**Application by Morgan Offshore Wind Limited for an Order Granting Development Consent for the Morgan Offshore Wind Farm Generation Assets**

**Deadline 1 – Written Representation**

The Navigation Risk Assessment (NRA), the Shipping and Navigation chapter of the Environmental Impact Report and draft DCO have been reviewed and we would like to comment as follows:

Figure 2: Moir Vannin and Morgan OWF distance from mean Douglas-Heysam routes

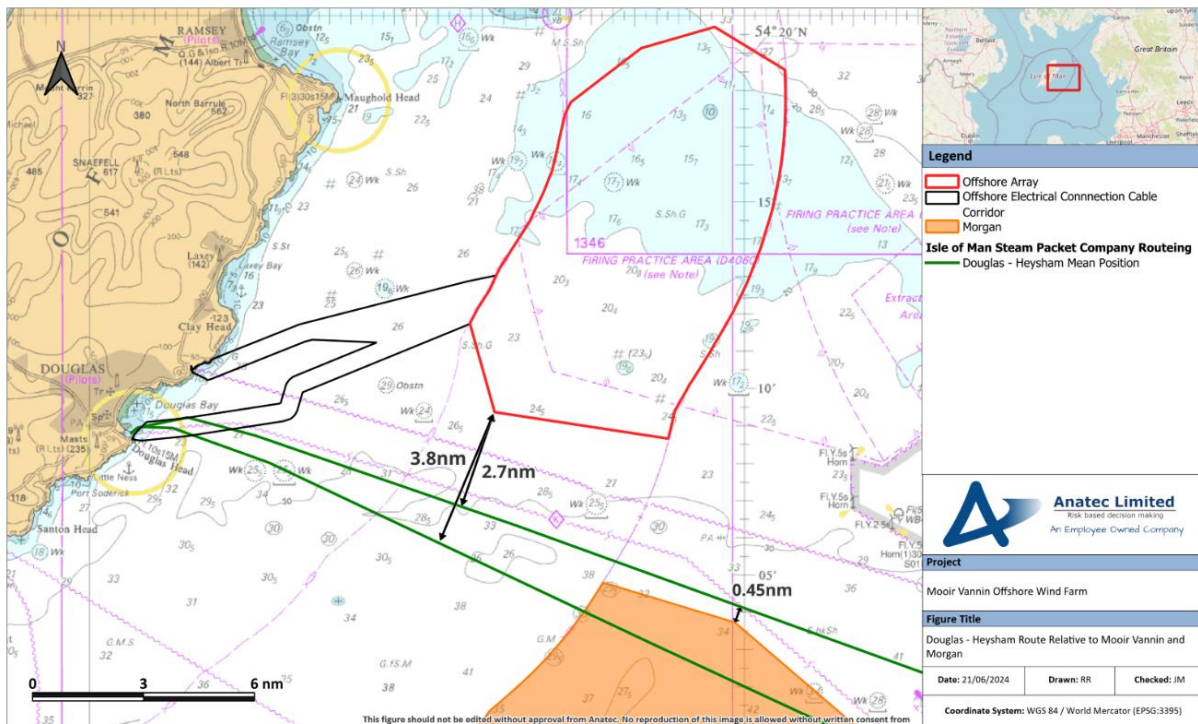
However, the proposed Moir Vannin in Isle of Man waters would reduce the sea space between the southern boundary and northern boundary of Morgan to 2.6NM. A separate assessment has been conducted and included in the CRNRA as Appendix D which concludes that collision and allision risks would be unacceptable, particularly for the passenger route between Heysham and Douglas. It is noted that the scoping report for Moir Vannin was issued in October 2023 and the planning timeline is behind the planning timeline

for Morgan. We would expect Morgan and Moir Vannin to reach agreement for increasing the sea space between the two sites to ensure the navigation risks are tolerable.
